Application No: EP/101/25/PL
Site Address: The Former Conservative Club 41 Sea Road East Preston BN16 1JN
Description of works: Changes to the parking layout with the addition of new grasscrete permeable parking area to the north and south sides of the building, which has permission to be used as a funeral chapel, to increase parking provision to 22 spaces (including a disabled space), and for improved hearse access, fencing to side boundaries and replacement planting to north side. This application may affect the setting of a listed building and is in CIL Zone 4 (Zero Rated) as other development.

This council's Planning & Licensing Committee considered this application at its meeting on Monday, 10th November.

Proposed site plan

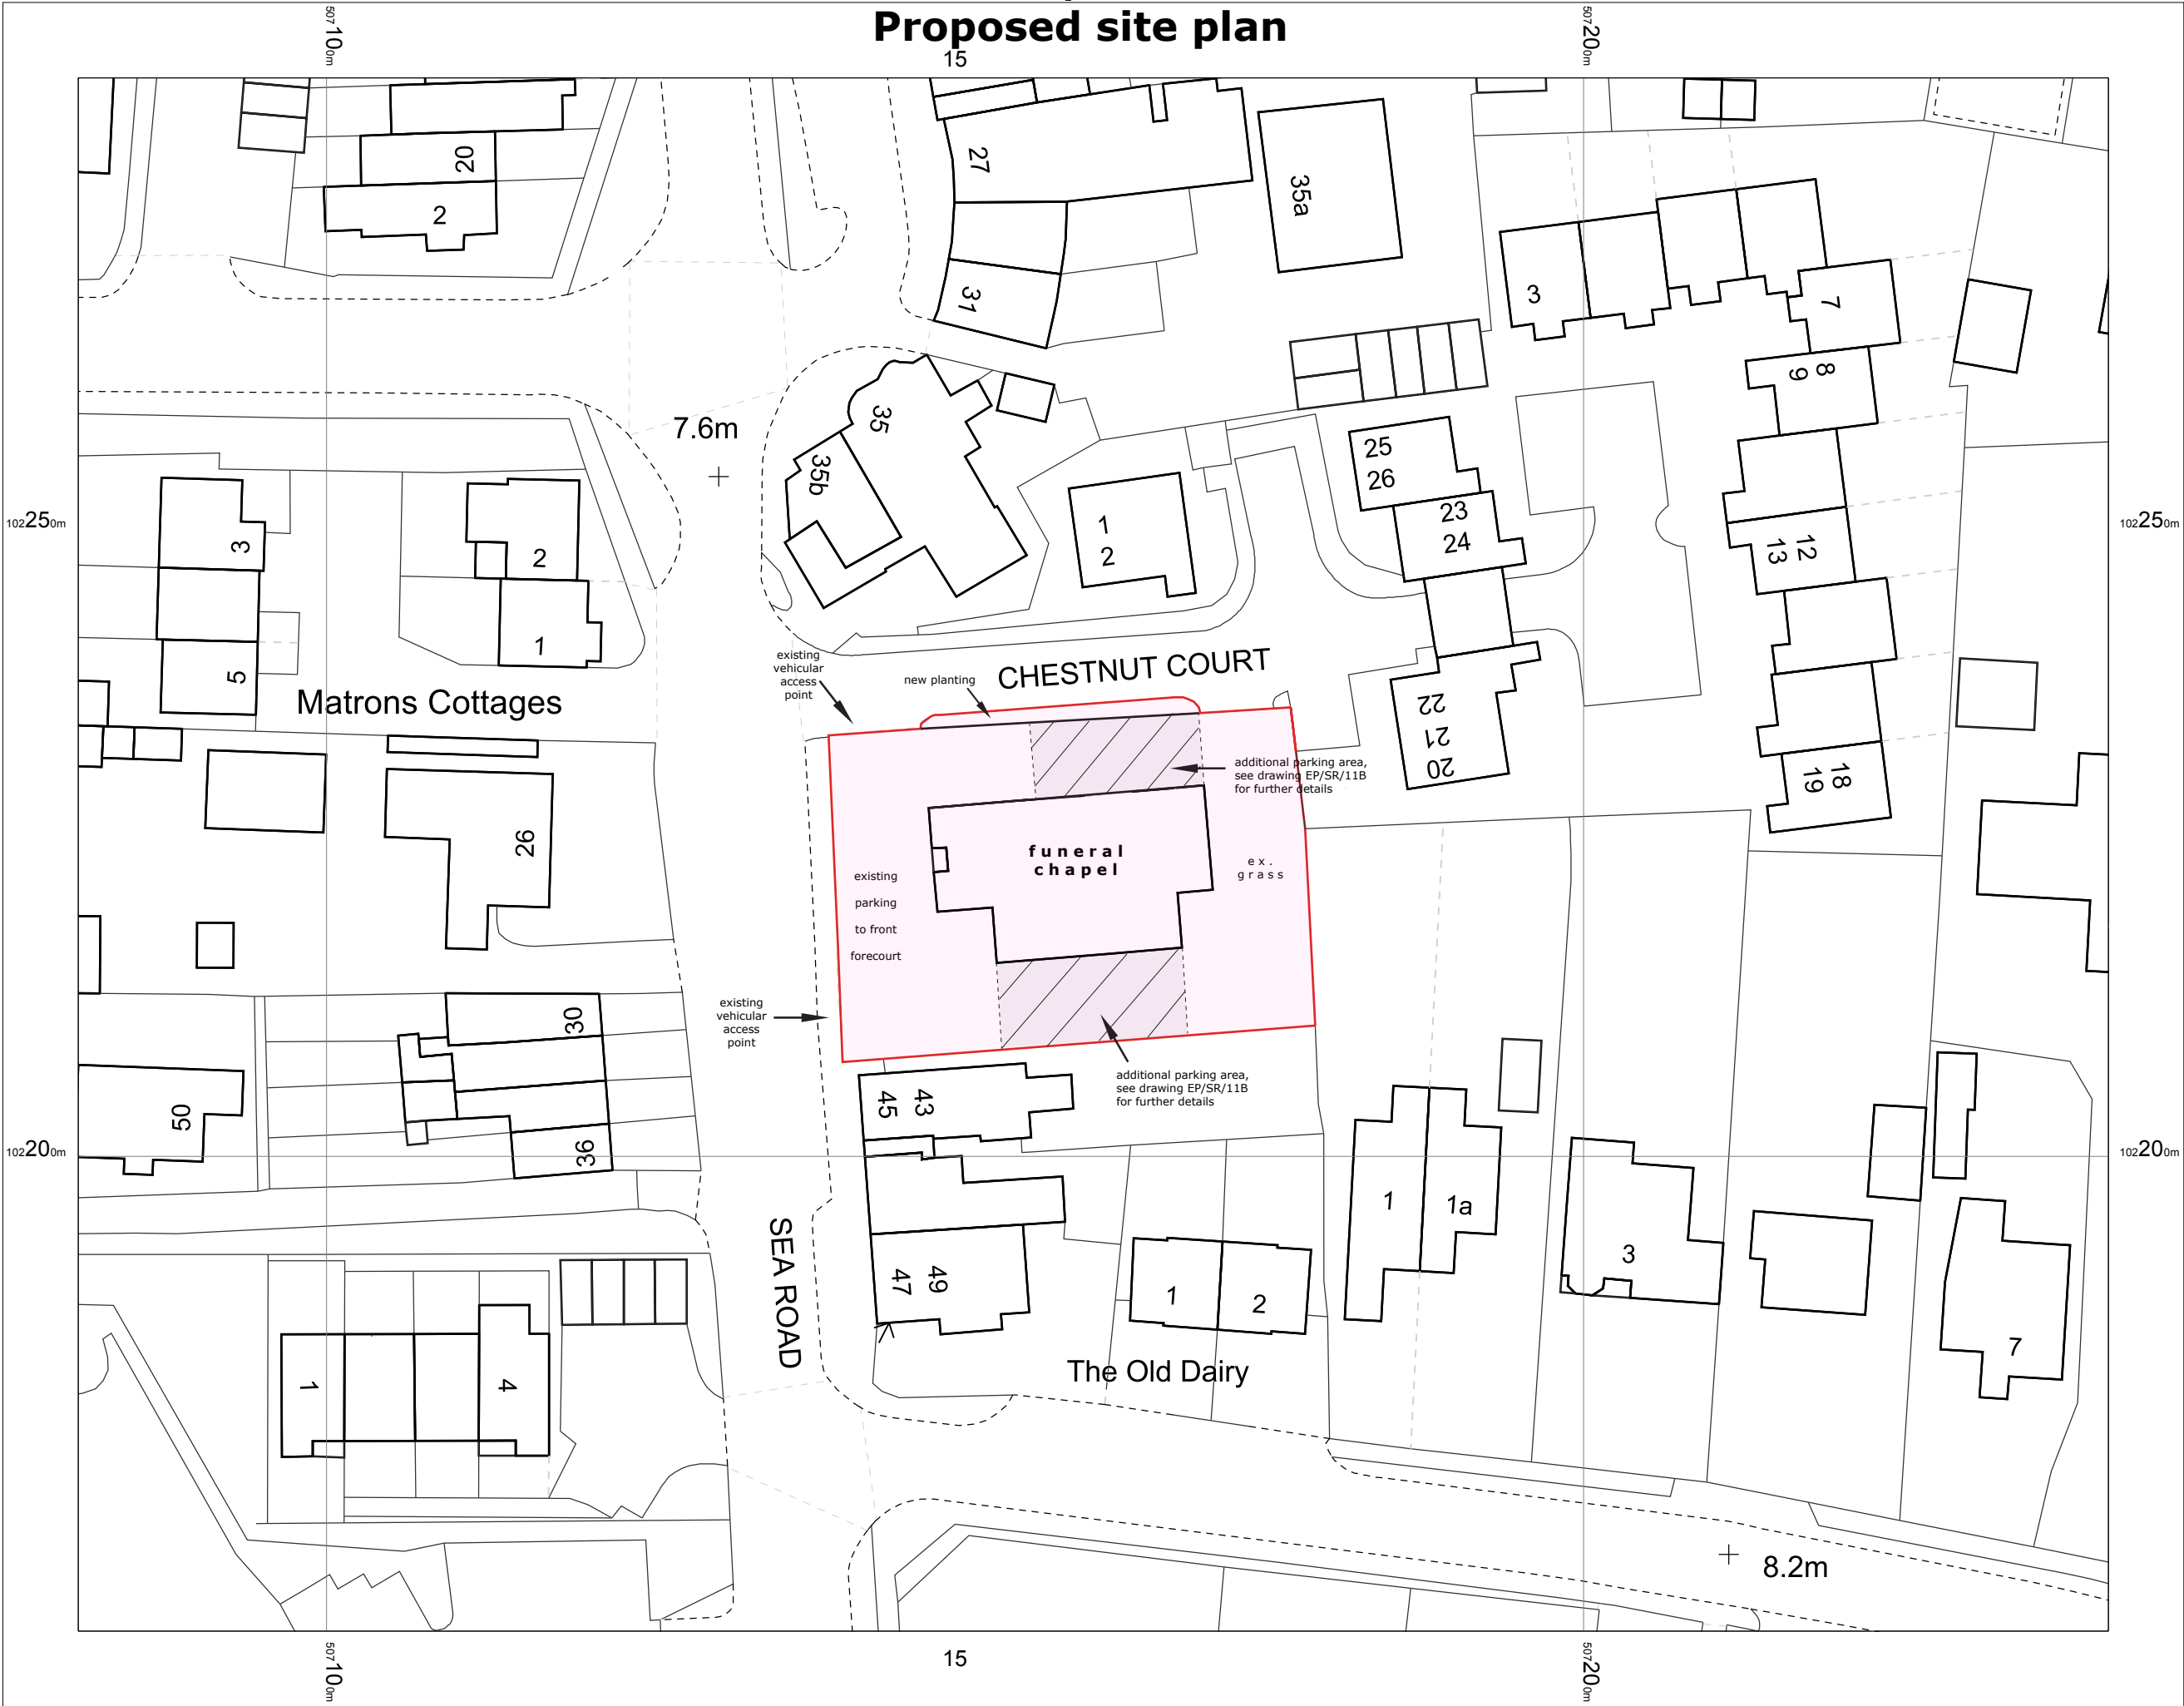
The committee agreed to object to this application as it felt the proposed parking layout would not be best for attendees. The proposed layout could make it impossible for some attendees to leave an event quickly in the case of an emergency if their leaving meant other attendees had to move their cars. Whilst it may not happen often, it would not be good for a funeral to be interrupted in that way.

The council had previously been told the hearse would arrive before other attendees and would be parked alongside the east elevation of the chapel. As that is no longer happening, that is a further reduction to parking available to attendees.

The committee felt any reduction of parking on-site would result in increased parking and traffic management problems in Sea Road and other adjacent roads. Local residents are already concerned about the impact of increased vehicle movements in the area.

Is the proposed format of parking spaces really better than herringbone parking on both northern and

southern boundaries?
